From: Martyn White
Sent: 09 November 2018 16:11
To: Planning.Responses
Cc: Anita Gardner
Subject: CM/23/18/L

CM/23/18/L

The site identified as Climping Mill comprises a number of buildings reflecting its past uses including residential, educational, and agricultural. The application relates to Mill Cottage, which is one of the older units on the site

Drawing Title
Mill Cottage
Elevations
As Proposed

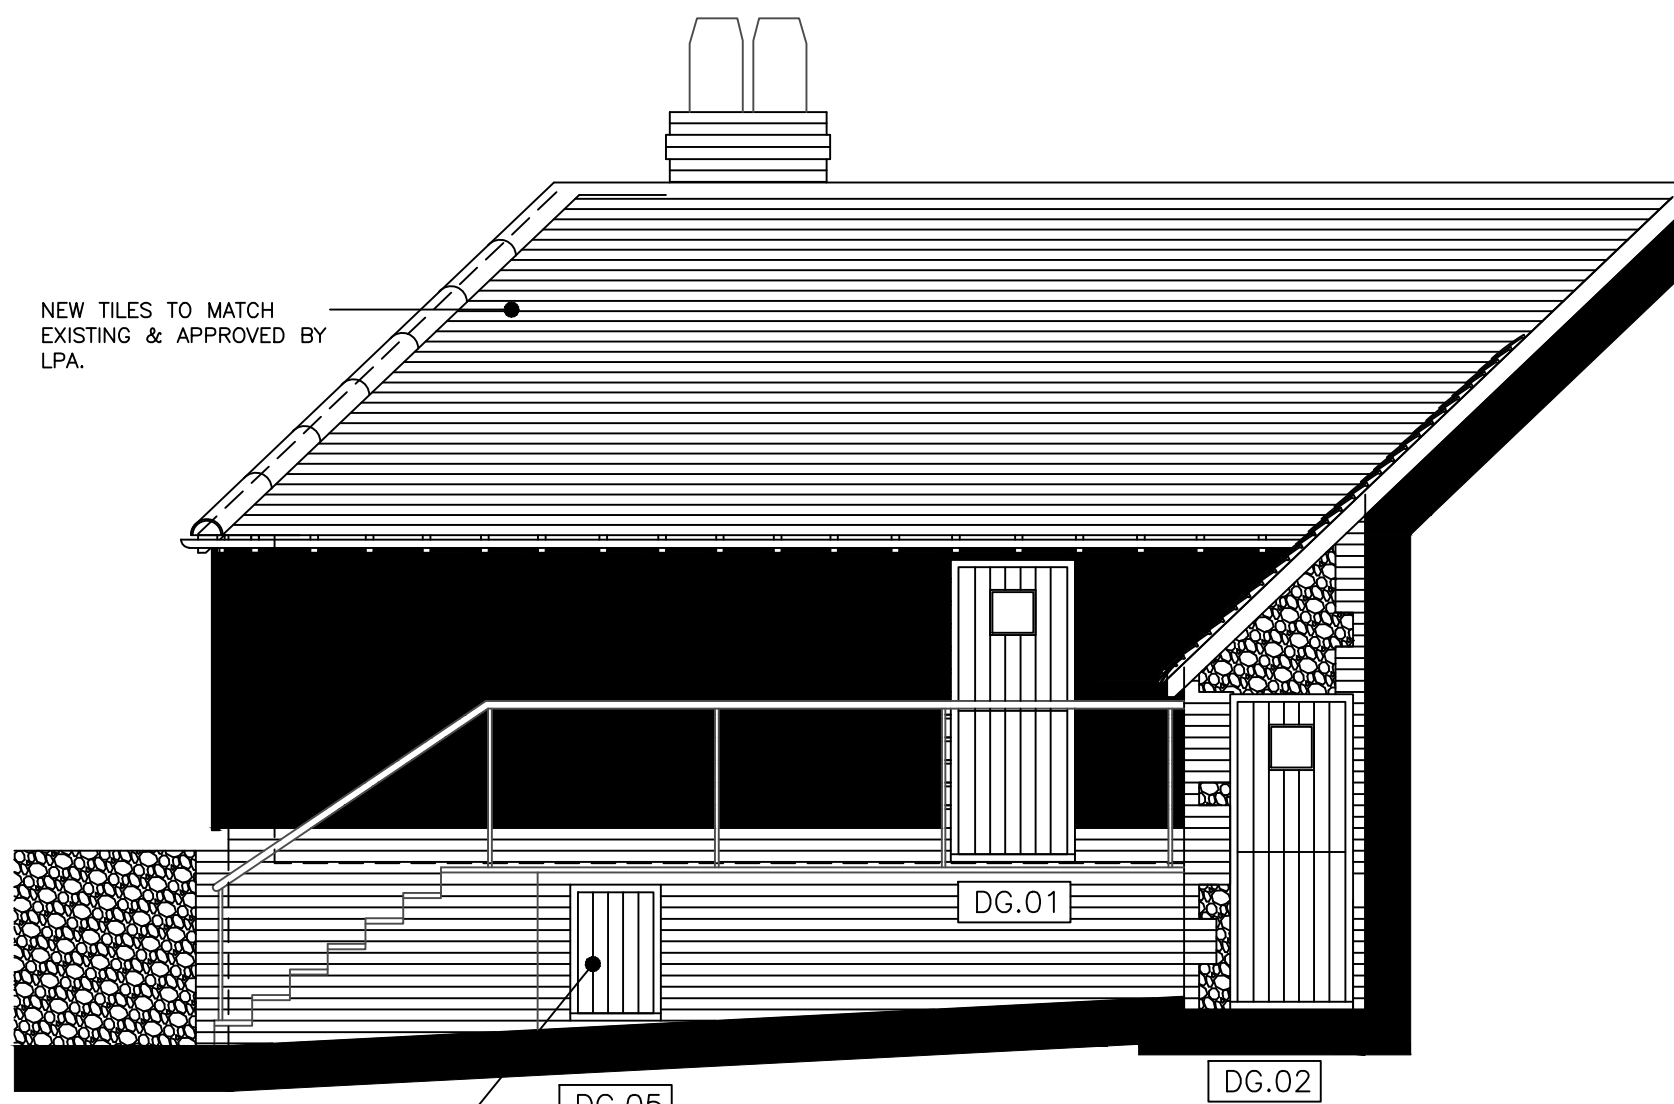
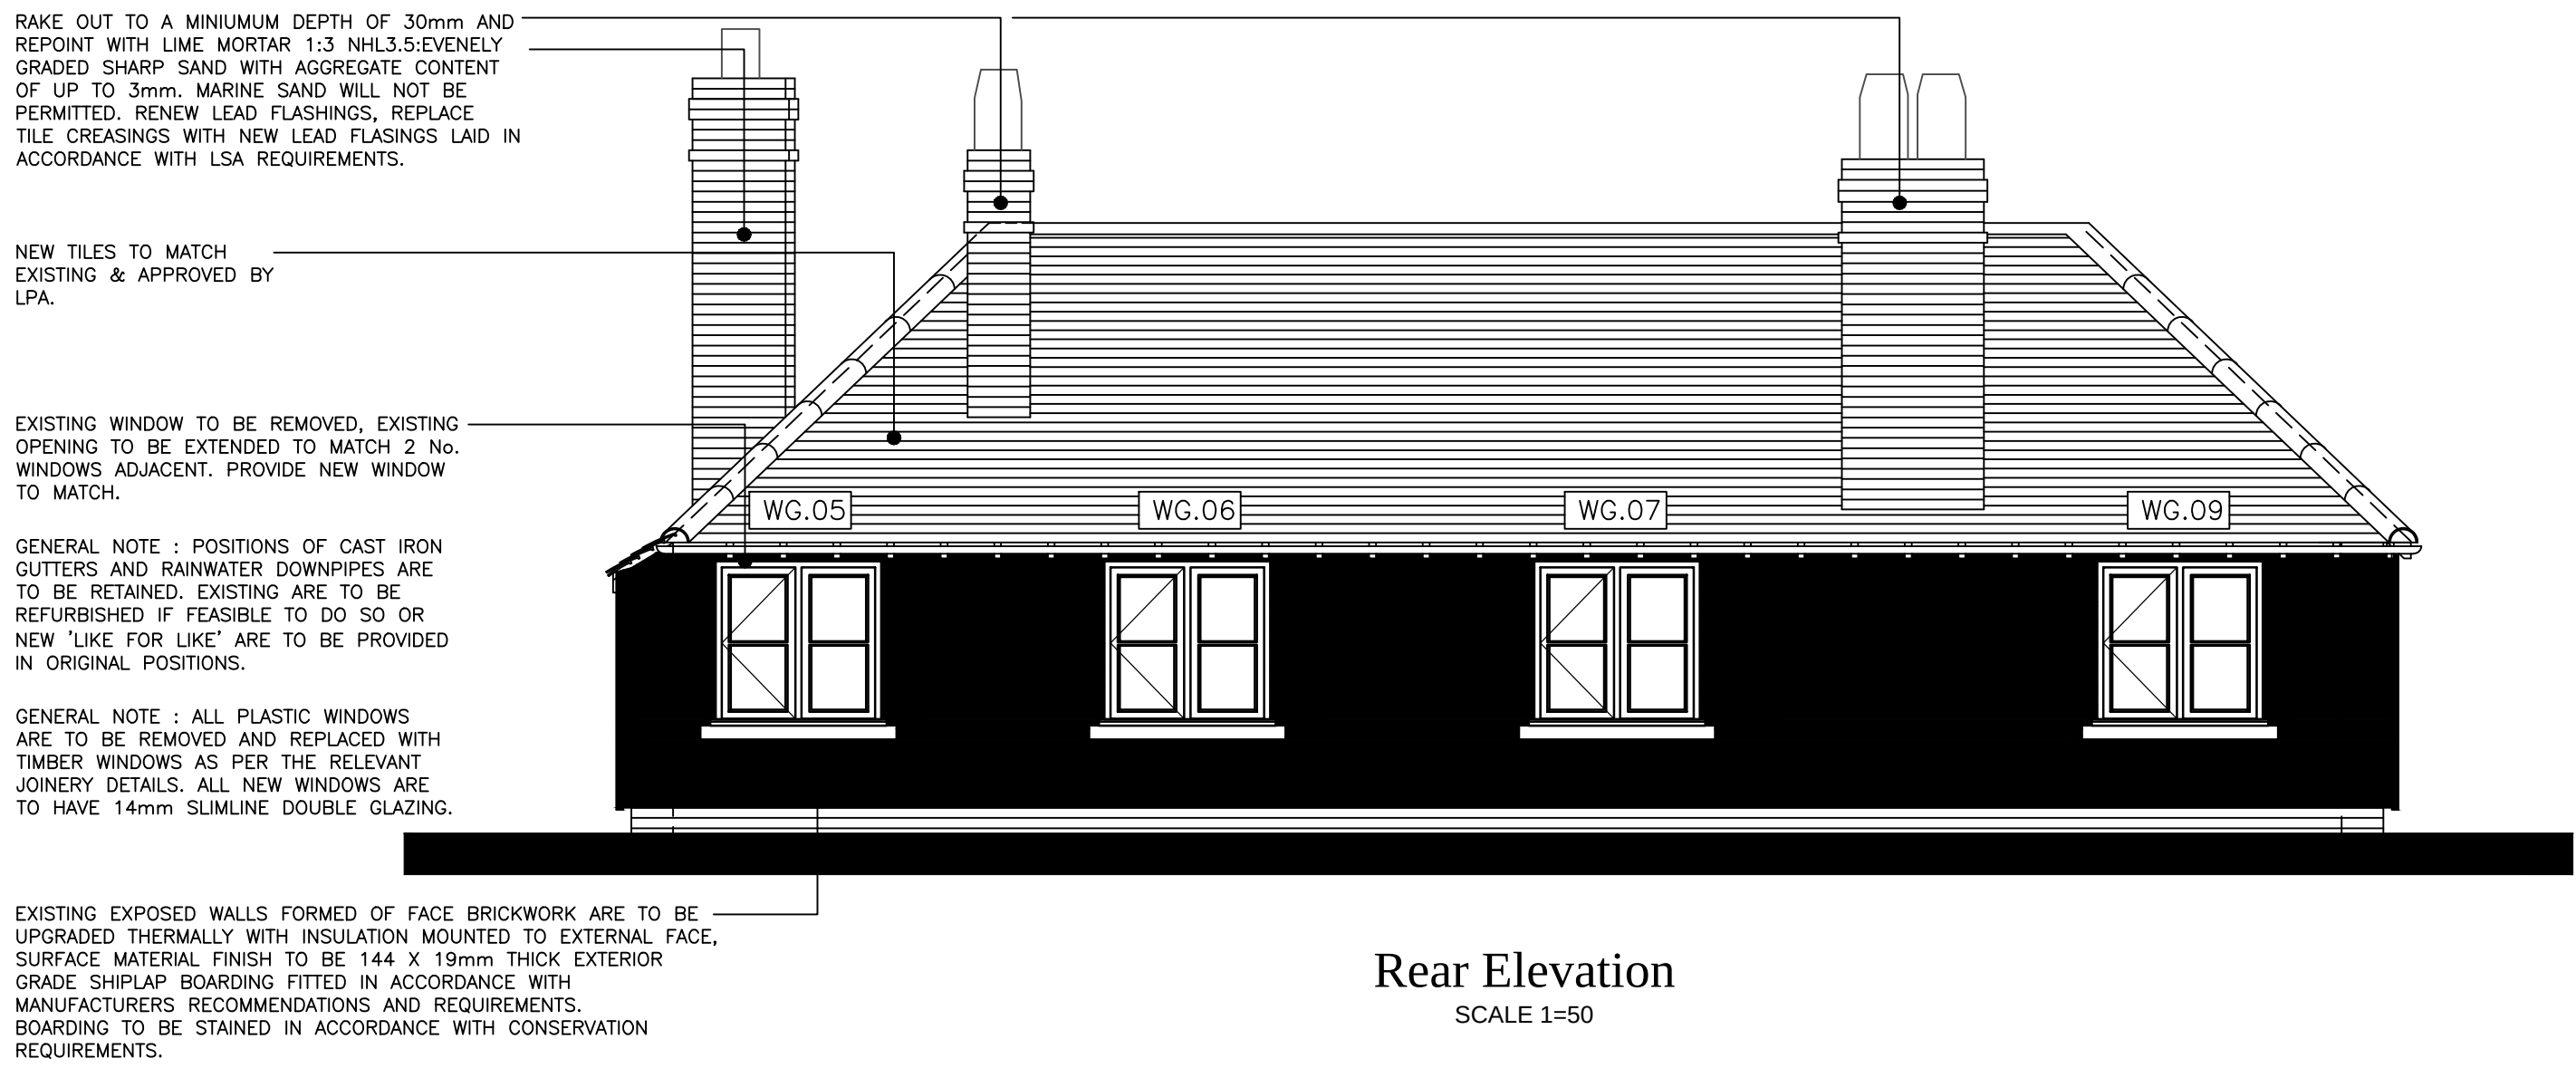
I note that the application seeks to introduce new windows and doors which are more in keeping with the appearance of the property. Such an issue can be supported, subject to details of their design. Further, the introduction of additional windows will not harm the character of the building, and their openings will be incorporated into the new cladding proposed. As I am unable to see the details of the windows and doors, they will need to be provided for by way of condition. The loss of the location of the fireplaces will enable the attractive chimney to be retained as part of the external appearance of the building.

The use of the proposed cladding will cover those parts of the building which have the later, more modern brick work. Such a proposal will enable the building to relate to the main listed building, which bears a similar characteristic.

Please provide details of the doors and window by way of condition, as well as details of the decking and the proposed railing. Please also request that the submission of details related to paint/stain colours for the external elevations.
